Approval of details reserved by condition imposed under ref AL/64/20/PL relating to Condition Nos 5 - pre-commencement site meeting with Tree Officer, 6 - mitigation method statement, 7 - archaeology, 8 - Construction & Environmental Management Plan, 13 - detailed level survey, 14 - materials & finishes, 15 - details of all new screen walls & fences, 16 - landscaping, 18 - energy efficiency measures, 19 - covered & secure cycle parking spaces, 21 - broadband, 22 - charging of electric vehicles and 25 external lighting.

Springfield Hook Lane Aldingbourne PO20 3TE

Condition Number 19

Title:-
Proposed Cycle Stores & Car Charging Plan

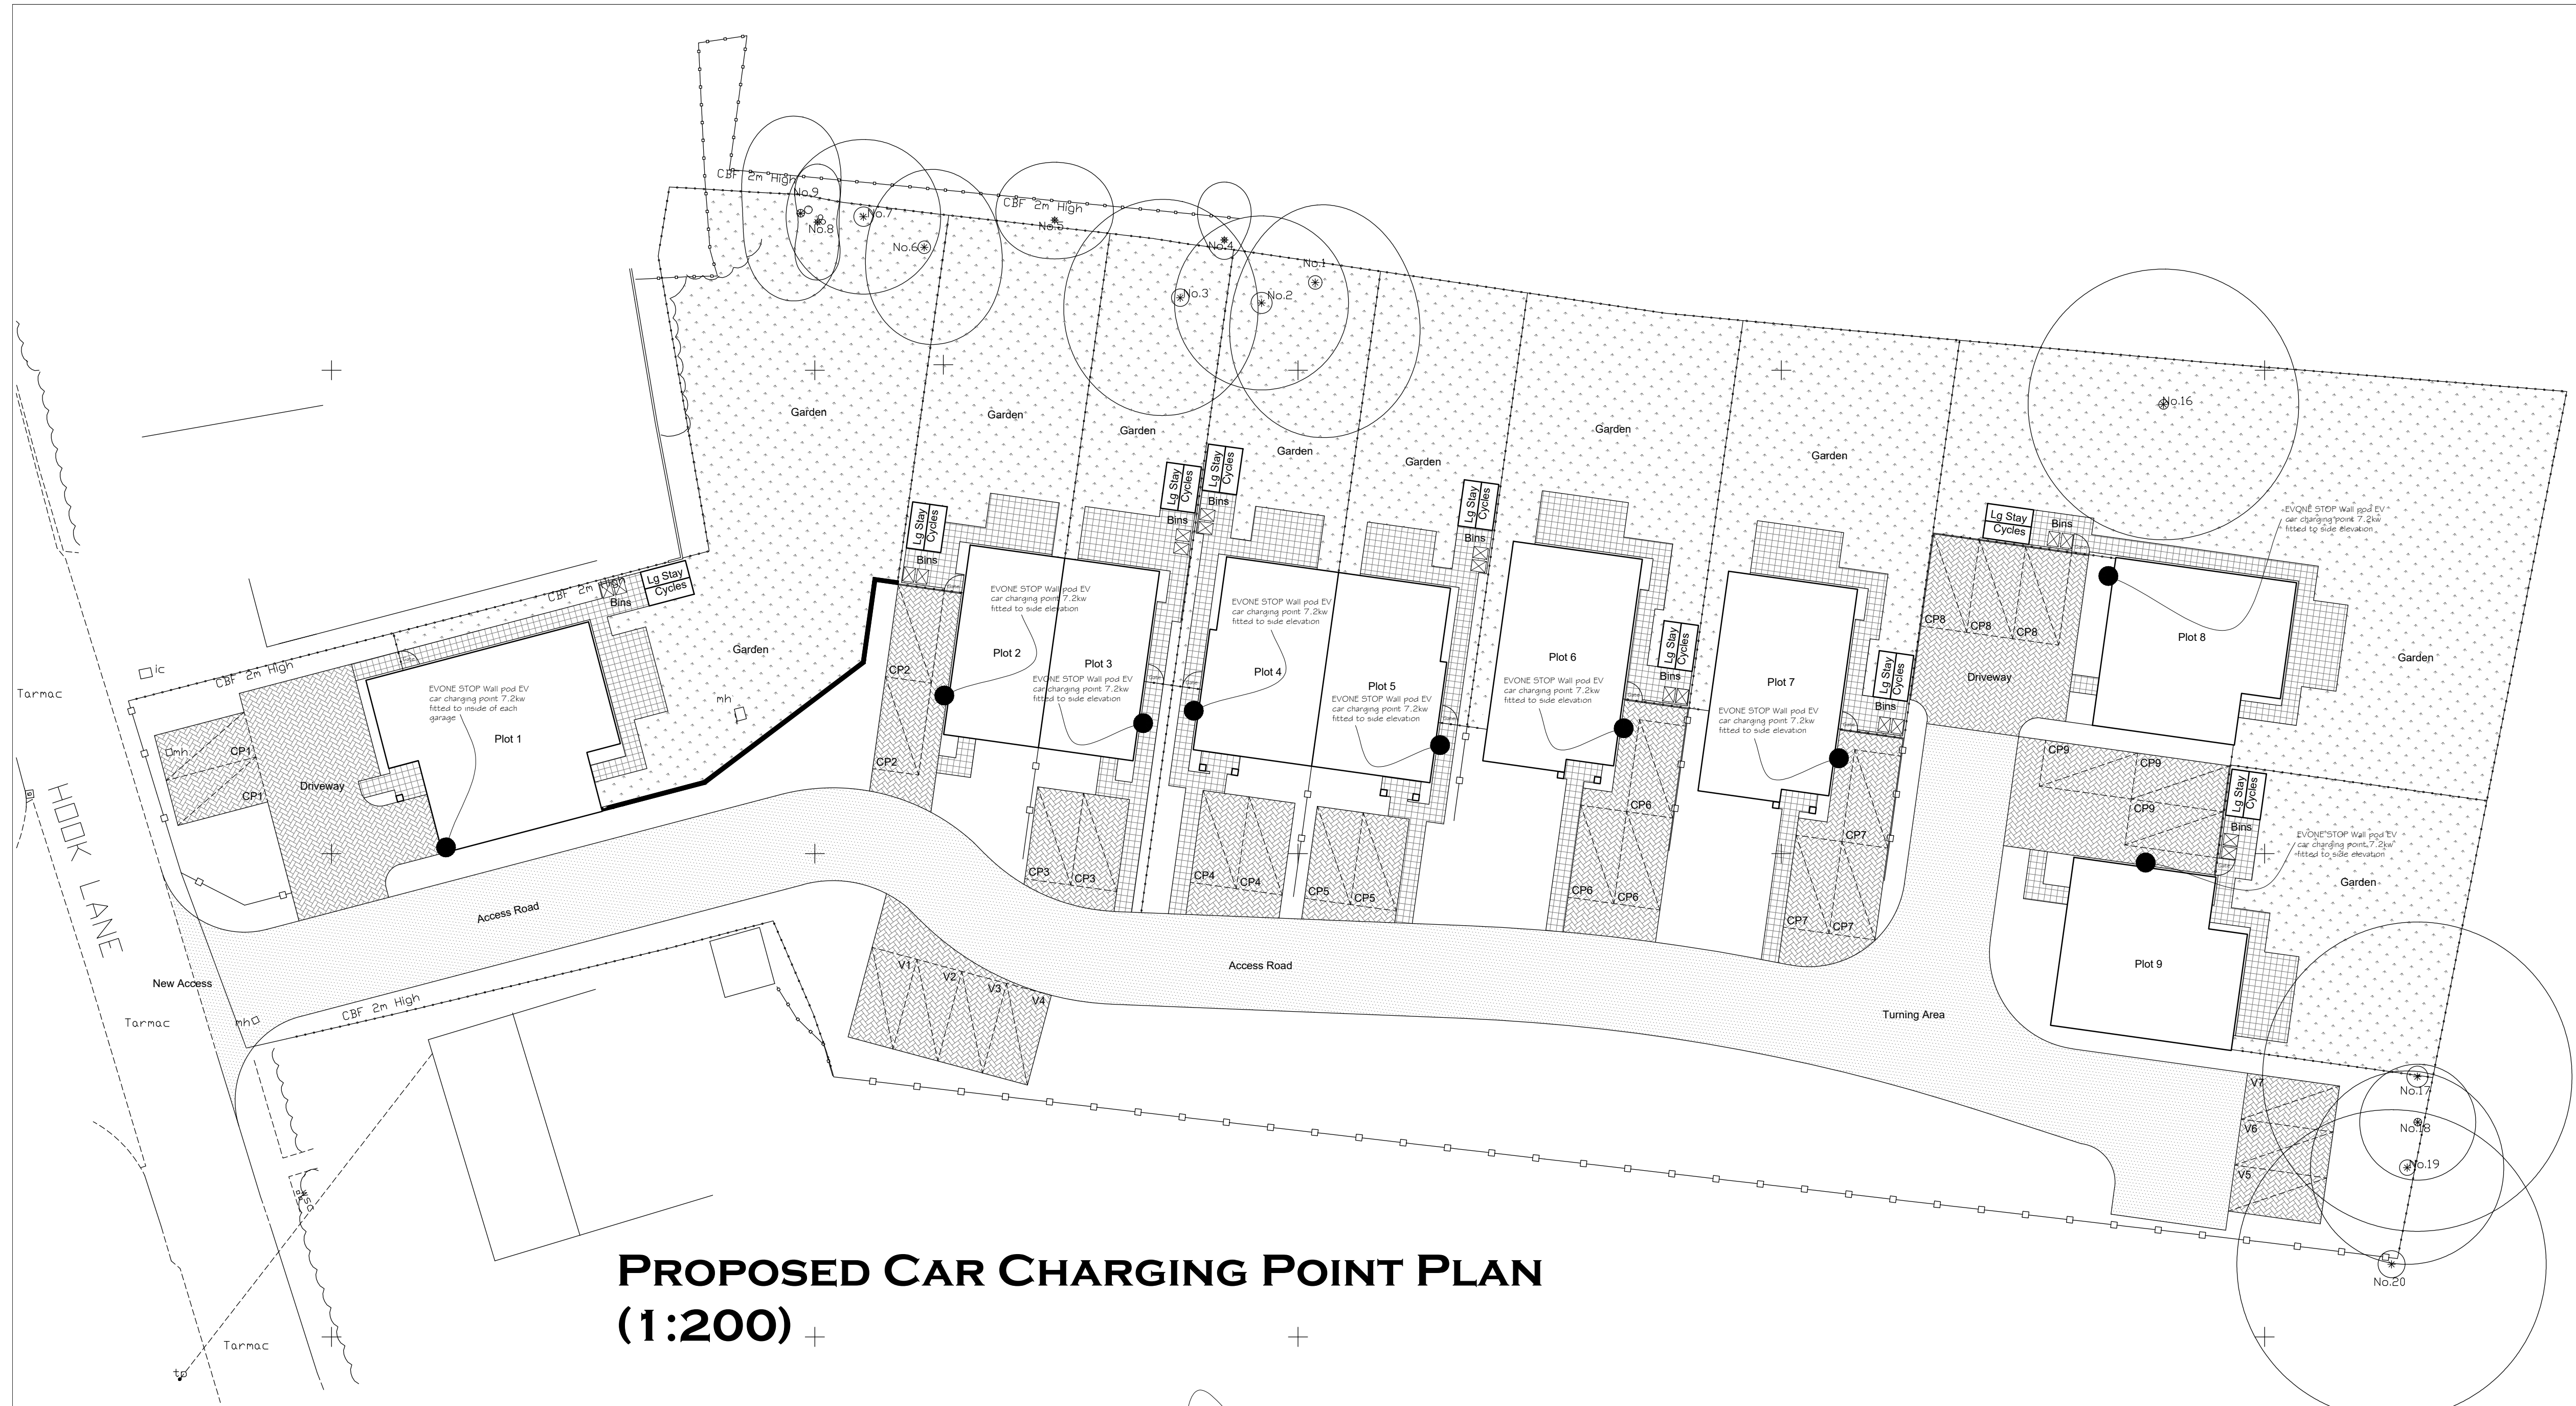
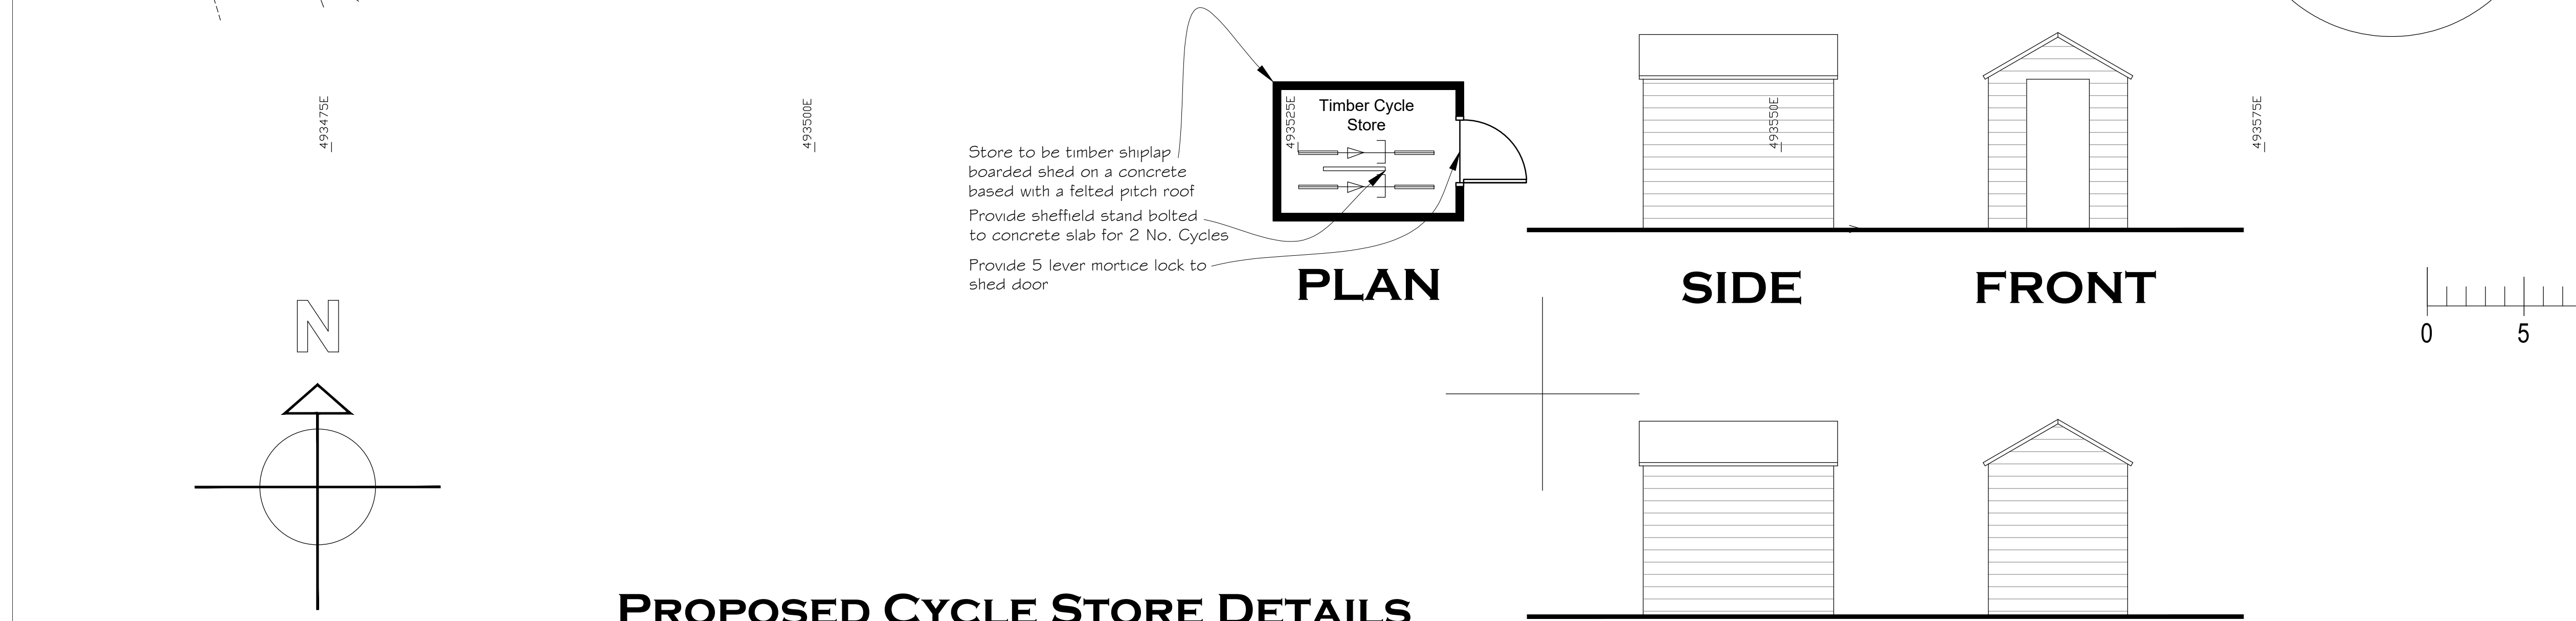
Drawing 03 "Proposed Cycle Stores & Car Charging Plan" (19/04/21) shows the location and design/appearance of timber cycle stores within the residential gardens of the development. The plan also states that each shed will have a 2 cycle Sheffield Stand bolted to the concrete slab and that the door will be secured with a 5 lever mortice lock.

This is appropriate and the condition is therefore fully discharged insofar as the submission of details relates and on the understanding that the new garden stores will be permanently retained in a

condition that is fit for purpose.and will continue to provide space for cycle storage.
